From: Brian Banister [REDACTED]
Sent: 21 September 2025 10:15
To: Planning.Responses
Subject: Arun Conservation Area Advisory Panel comments on applications

The **Arun Conservation Area Advisory Panel** wish the following comments to be taken into account in the determination of the applications:

LU/141/25/PL - 57 River Road, Littlehampton

FLINT ELEVATION OF WAREHOUSE
RETAINED + REPAIRED

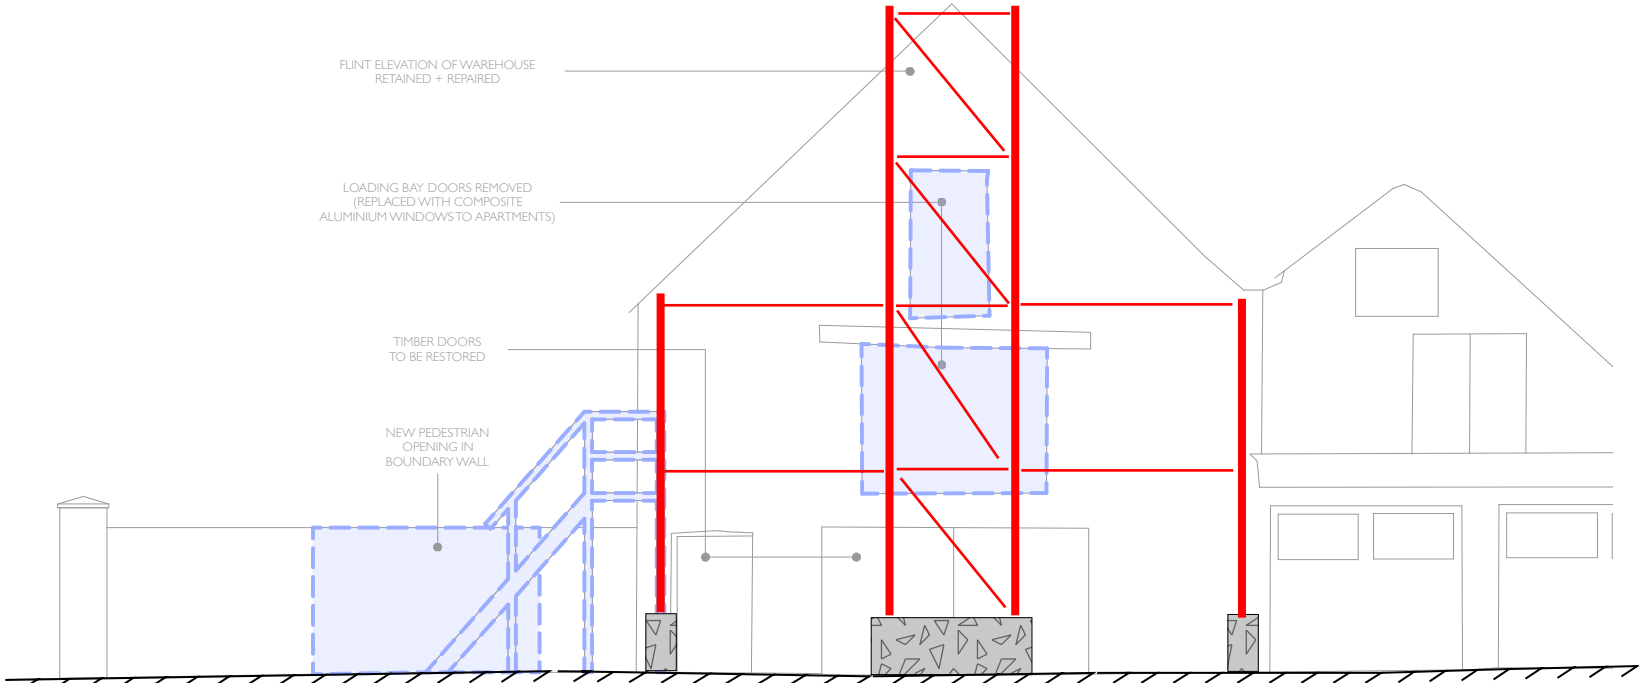
The Panel considered that the replacement of the very large concrete repair patch on the facade of the building with properly formed flintwork (using flints from the demolished part of the structure) would be appropriate.
